Re: Planning application **6/2023/0005/HOUSE**

MRS GLORIA ROWLAND
Home Extension
391 St Albans Road West, Hatfield, AL10 9RU
Proposed Site Plan

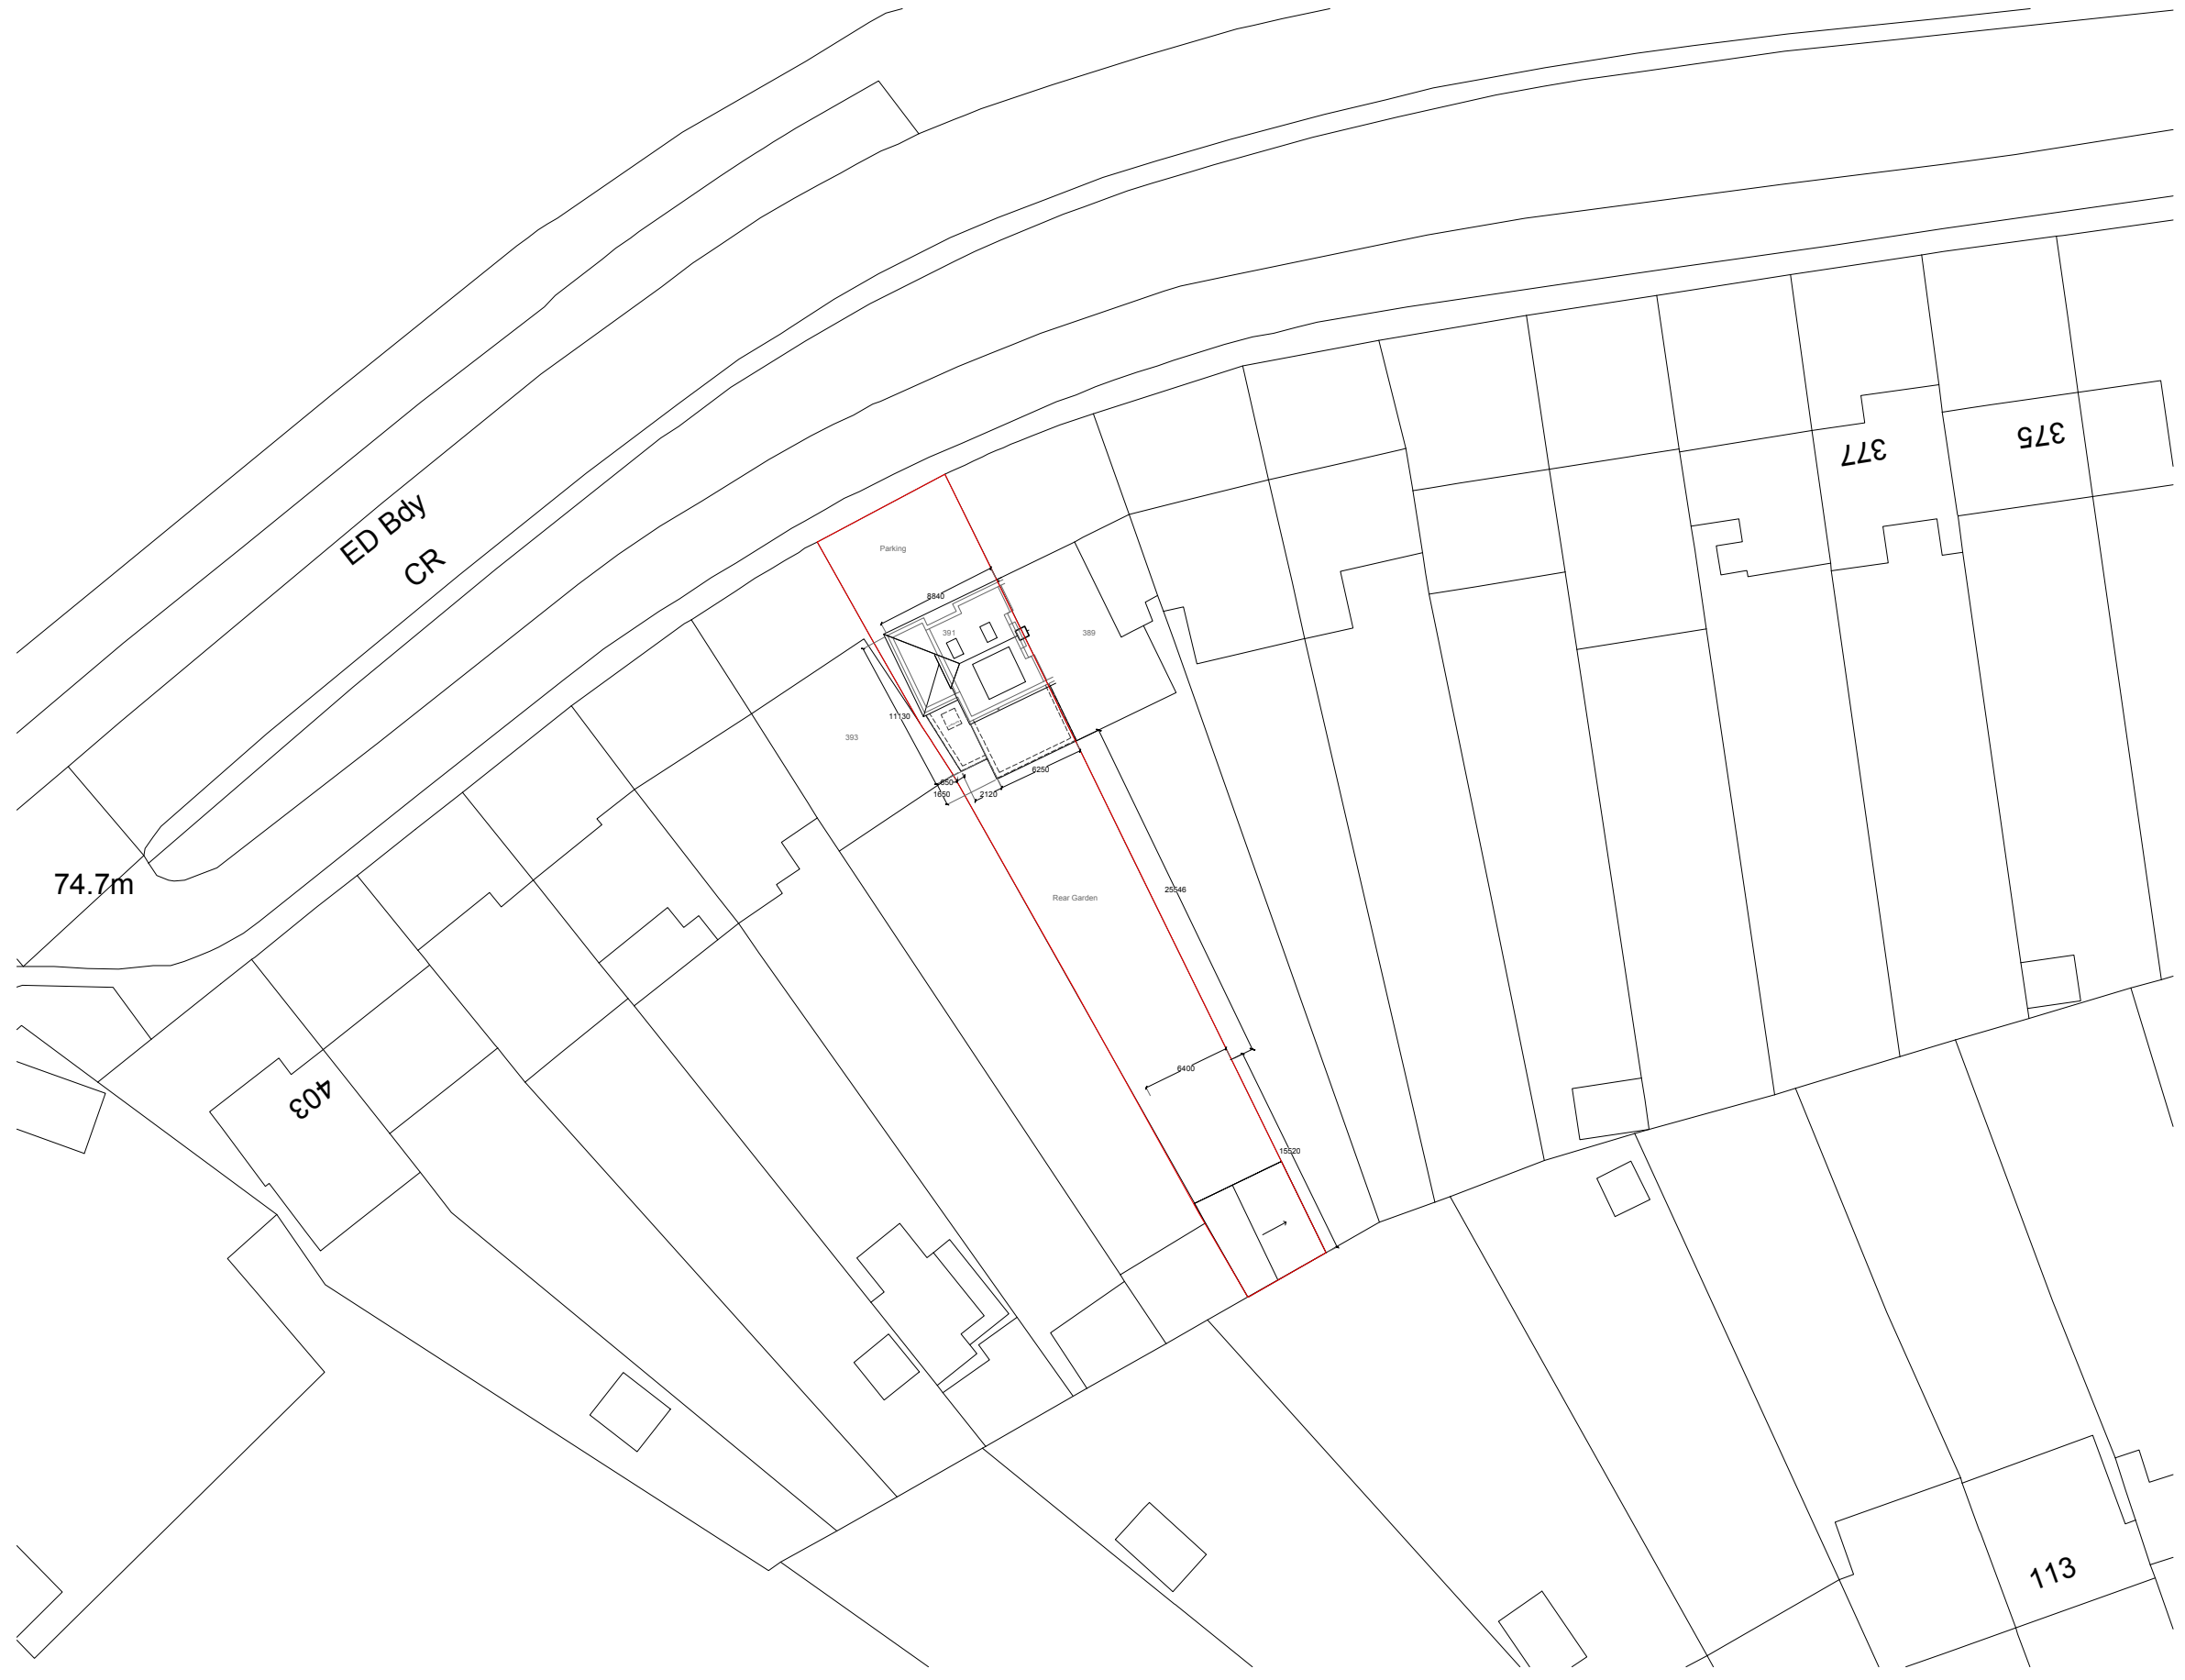
The existing elevations and site plan are inaccurate. There are currently no roof windows on the front elevation and no dormer style structure on the rear. The rear of the property currently has a double storey extension with a pitched roof, joined to the main roof, which is omitted from the 'Existing Elevations' document.

There is already a large outbuilding which has been omitted from the proposed plans. Permission was granted previously (S6/2014/2413/LUP) for a 'games room' and the plans stated 4800mmx4200mm. I do not have exact measurements but it is at least 8000mm in length.
